Recommendation Report for Planning Permission for Works or Extension to a Dwelling

REF NO: FP/267/21/HH

LOCATION: 23 Links Avenue
Felpham
PO22 7BL

PROPOSAL: Single storey flat roof rear extension with associated lantern. Single storey flat roof side porch and erection of a detached garage including demolition of existing garage.

Proposed Block Plan
Scale 1:500
© Crown Copyright and database rights 2021
OS 100047474

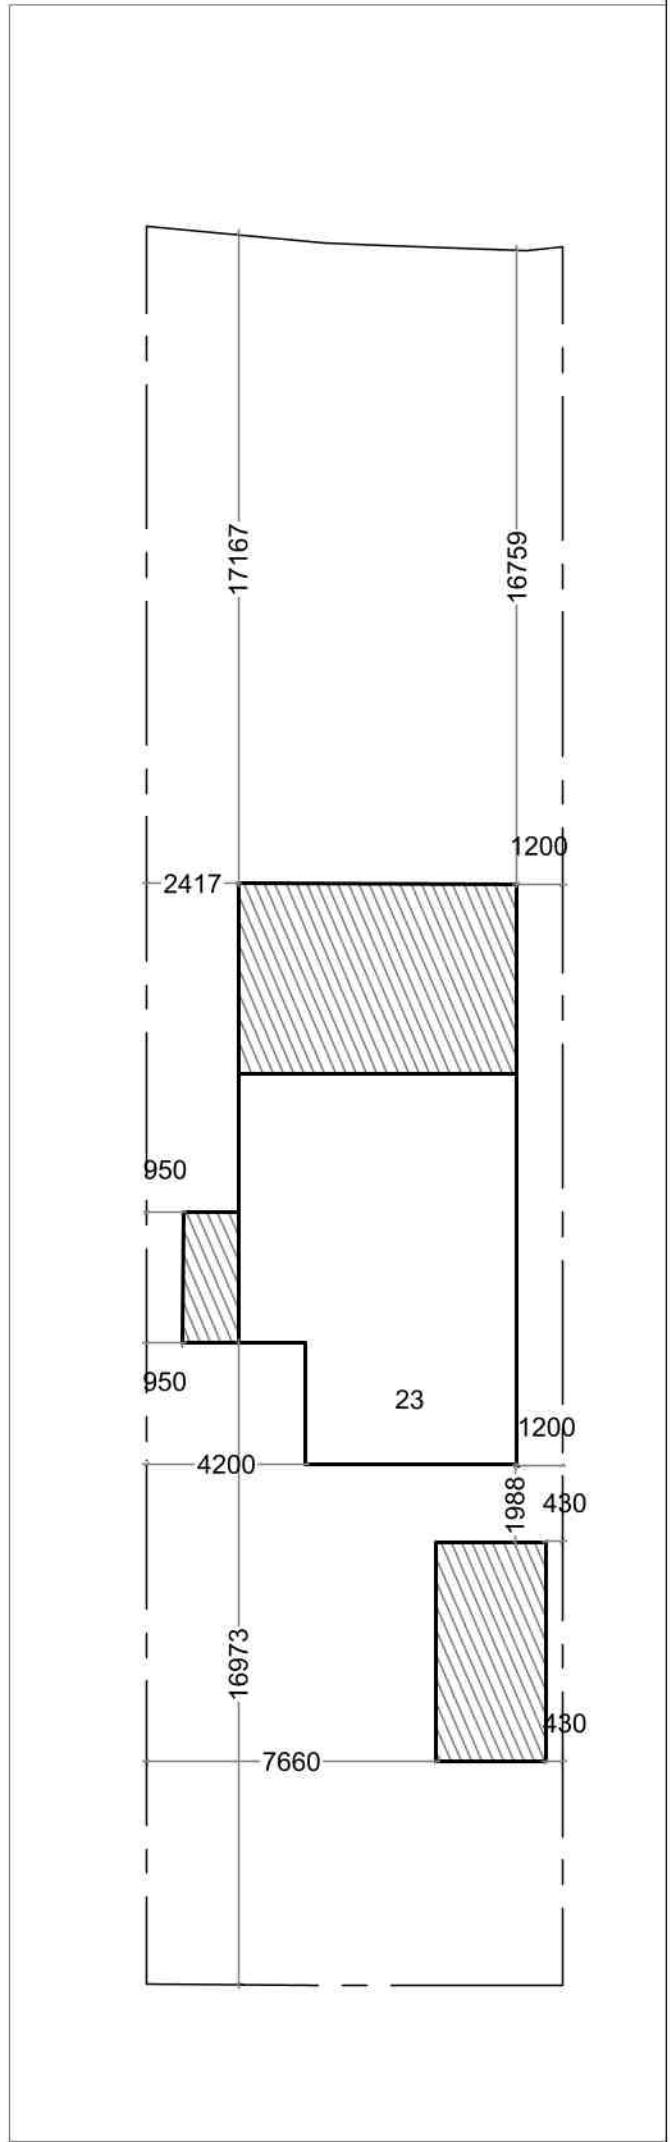
The property is detached and has a detached single storey garage which is located forward of the principal elevation to the southern side. This will be removed and re built to the northern side.

Around 17m is retained to the rear boundary and with no properties to the rear, the development does not result in harm upon this elevation.

Site	23 Links Avenue, Felpham, Bognor Regis PO22 7BL	Date	05.01.2022
		Sheet	21-1944 D05 Rev 0
		Job	New Extension & New Garage
		Scale	As Shown@A1
		Title	As Shown

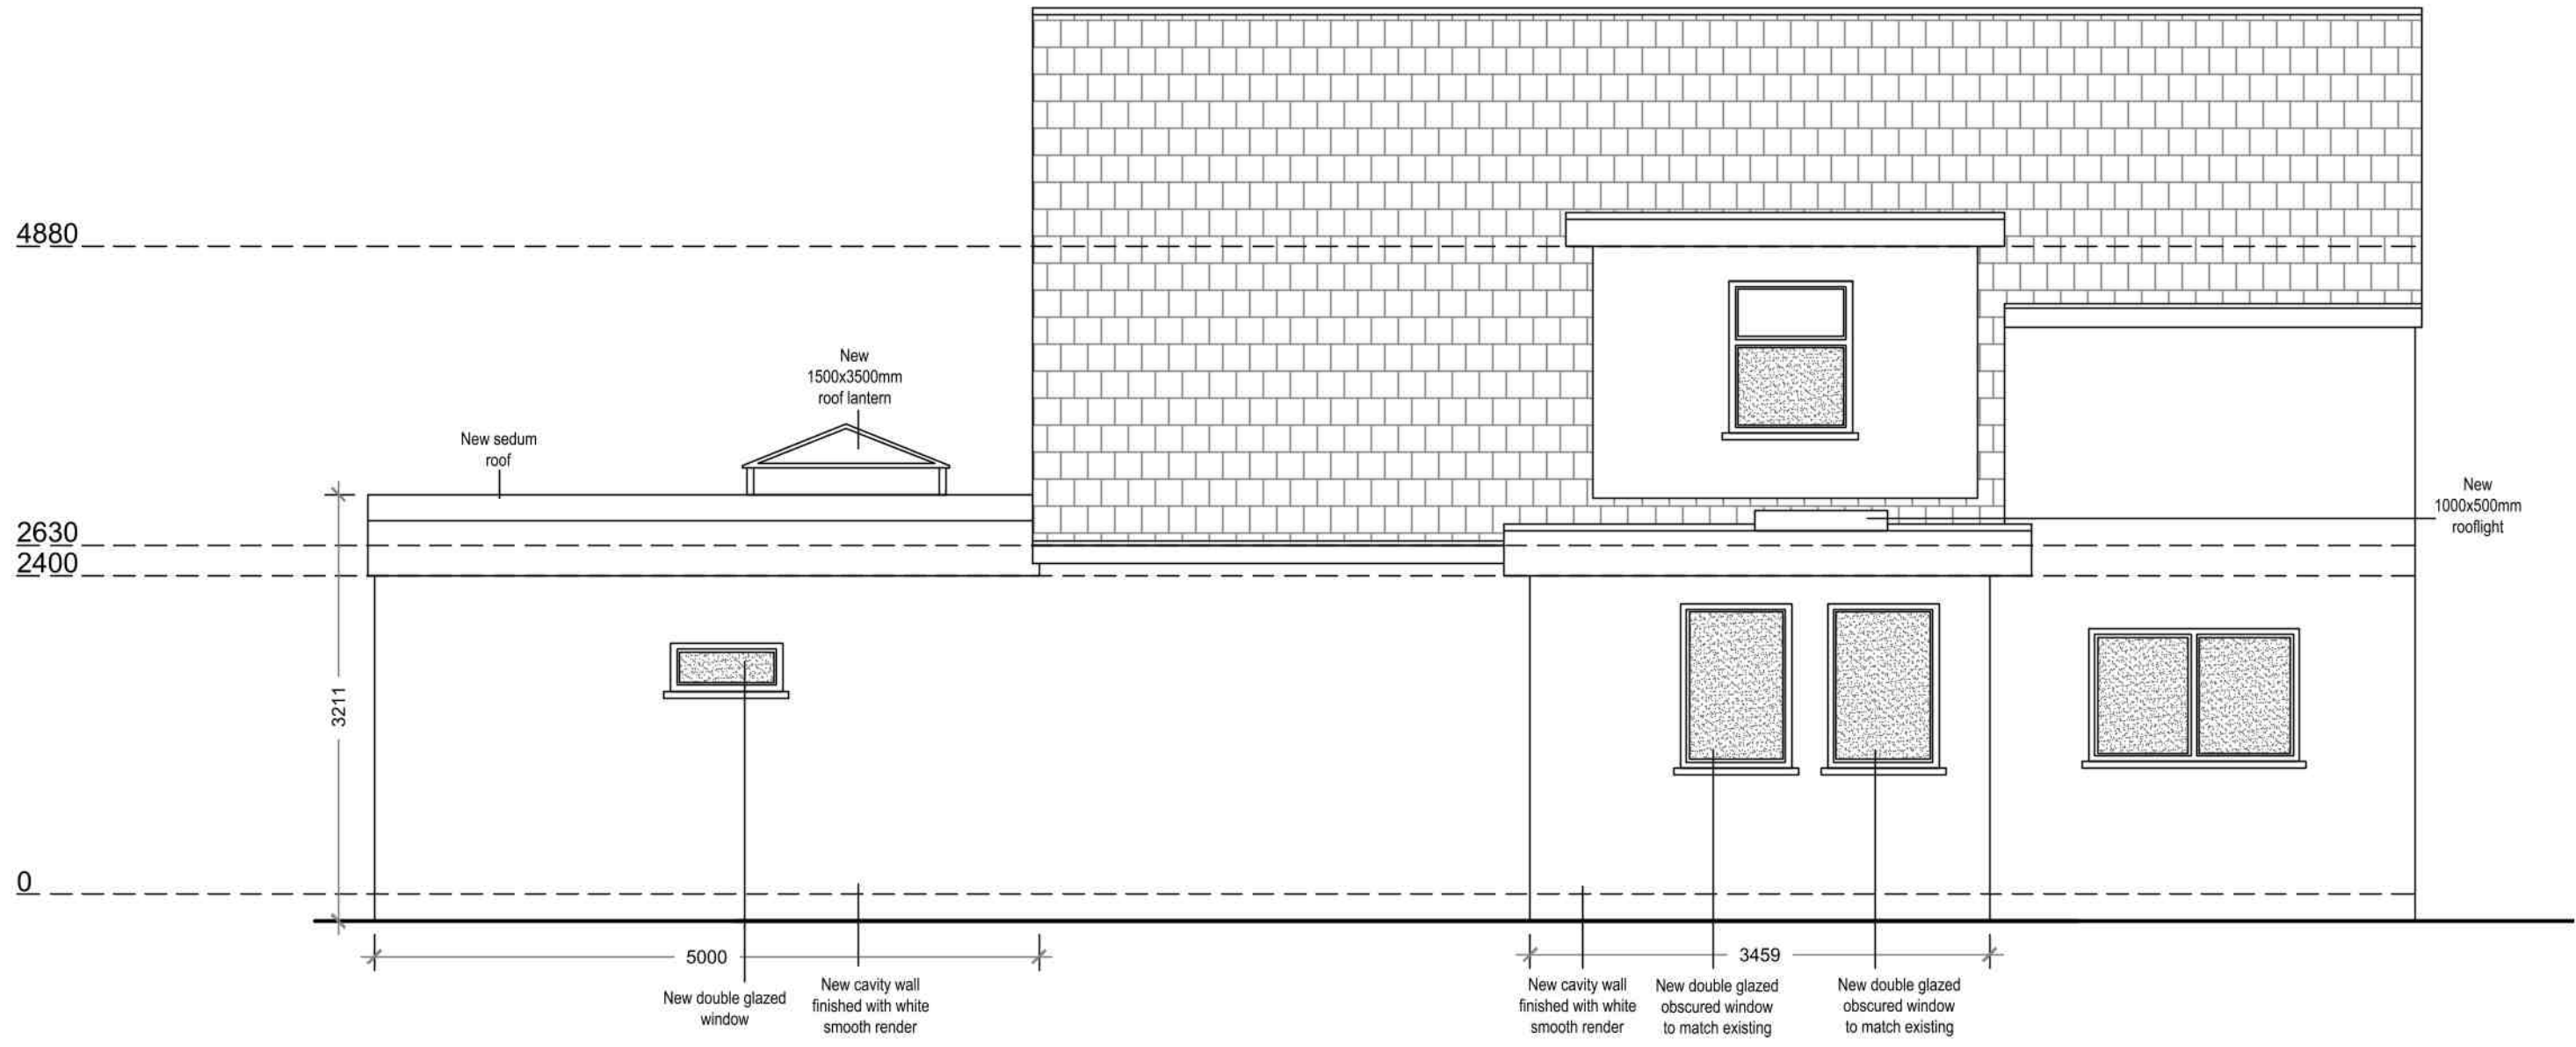
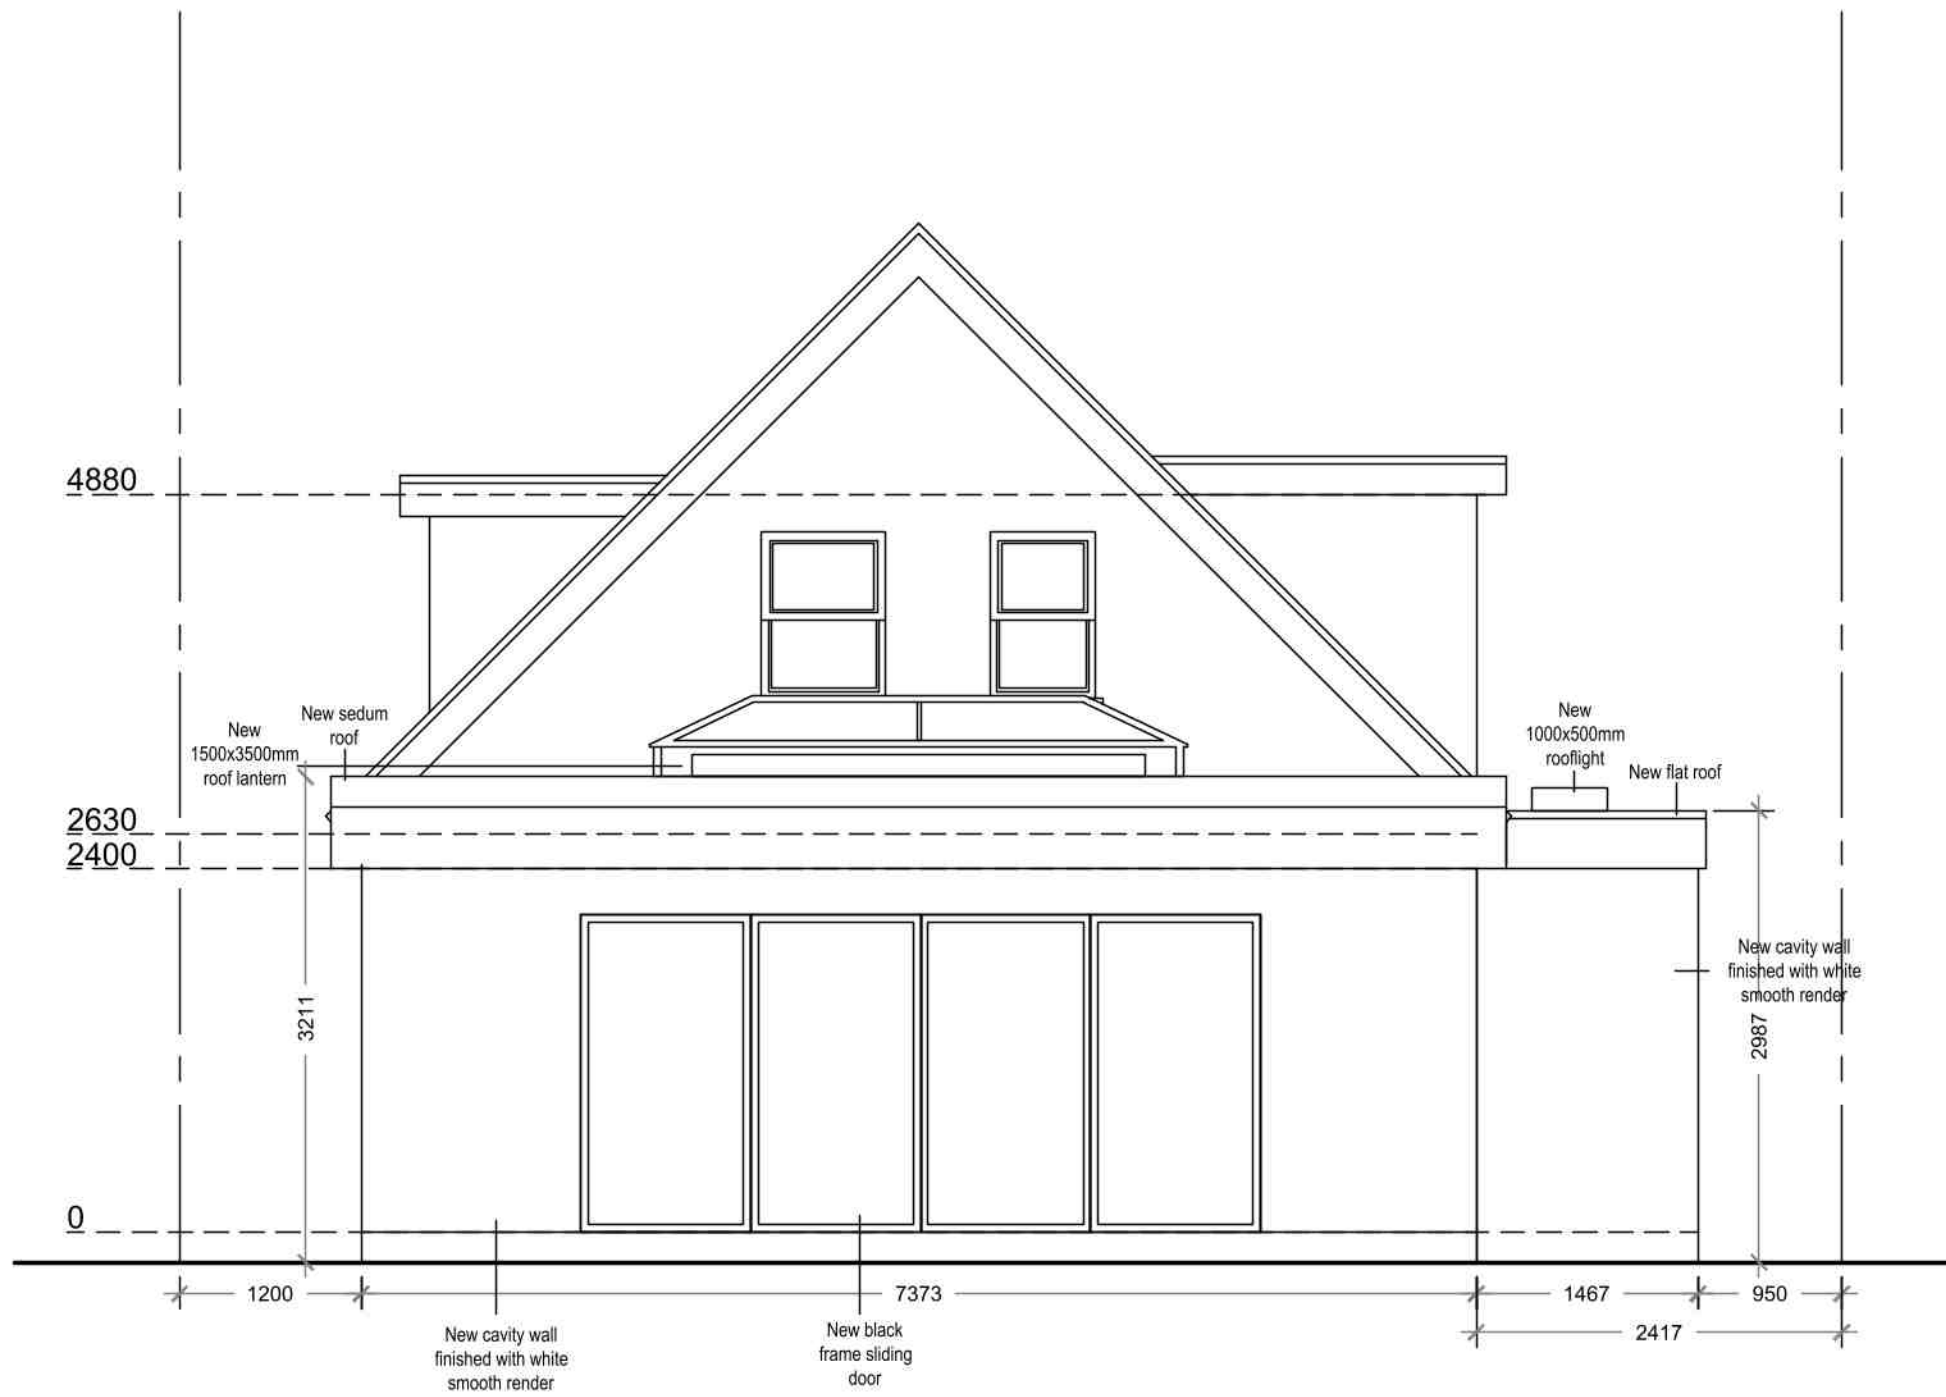
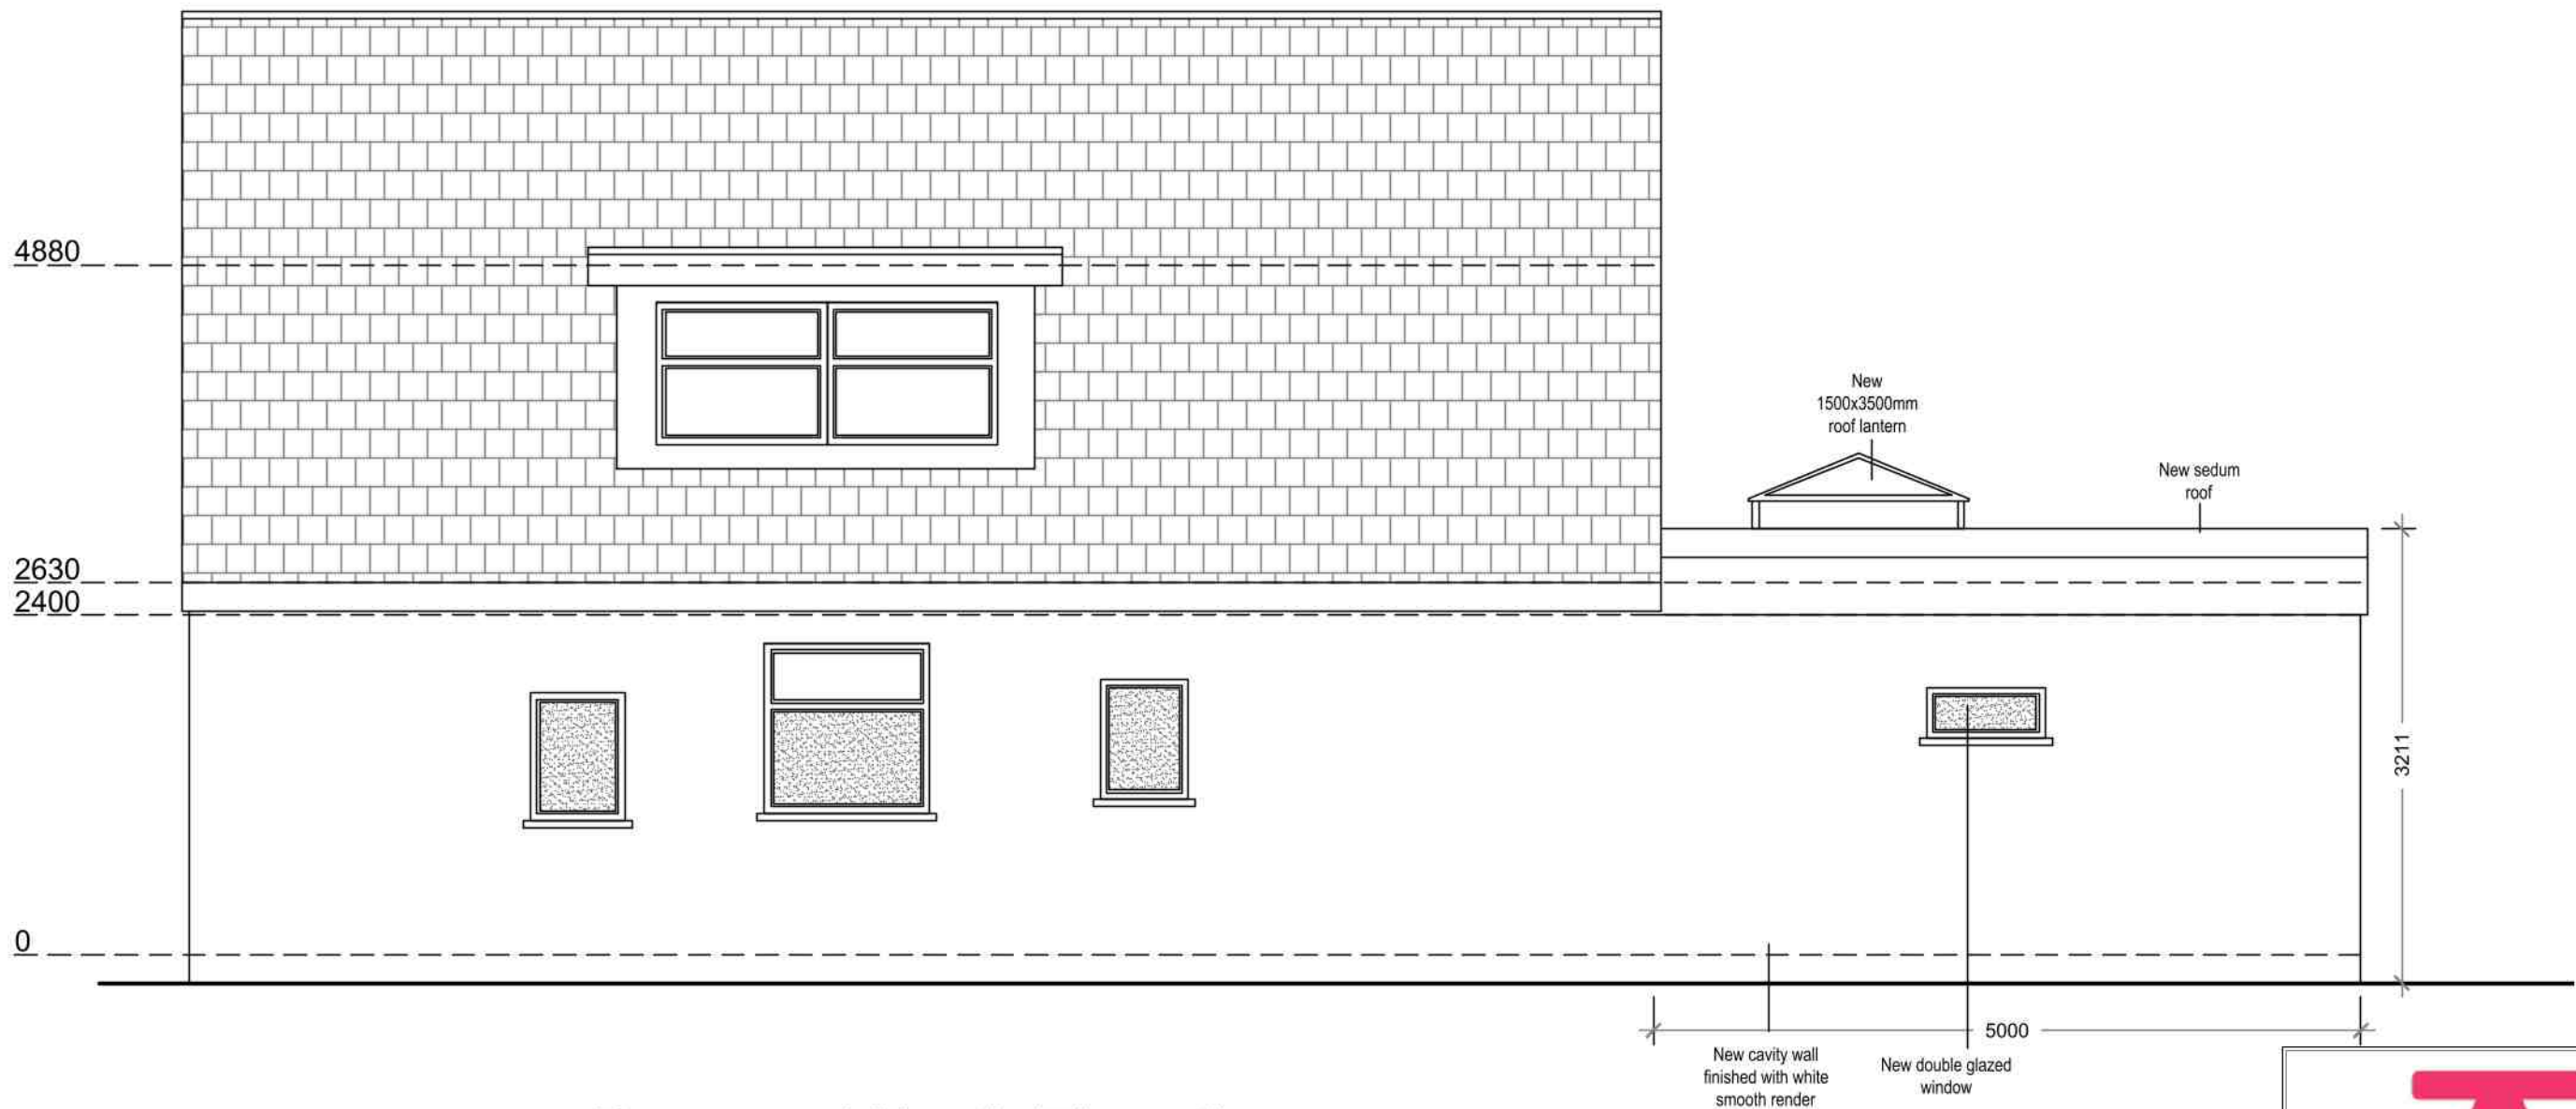
The extension will have a depth of 5m and extend along the full rear elevation. This will have a flat roof with a height of 3.2m. This does extend beyond the rear building line of the neighbouring dwellings by some distance however the extension retains 1.2m and 2.4m to the side boundaries and as such sufficient space is retained to the boundaries to ensure the development does not appear adversely overbearing or overshadowing. The boundaries feature planting to both sides which helps to restrict much of the view.

The extension will have 2 small windows to the side elevations however located at ground floor and with sufficient boundary treatment in place views are not considered additional to that which is already achieved from standing in the garden. Doors to the rear will overlook the garden of the host dwelling.
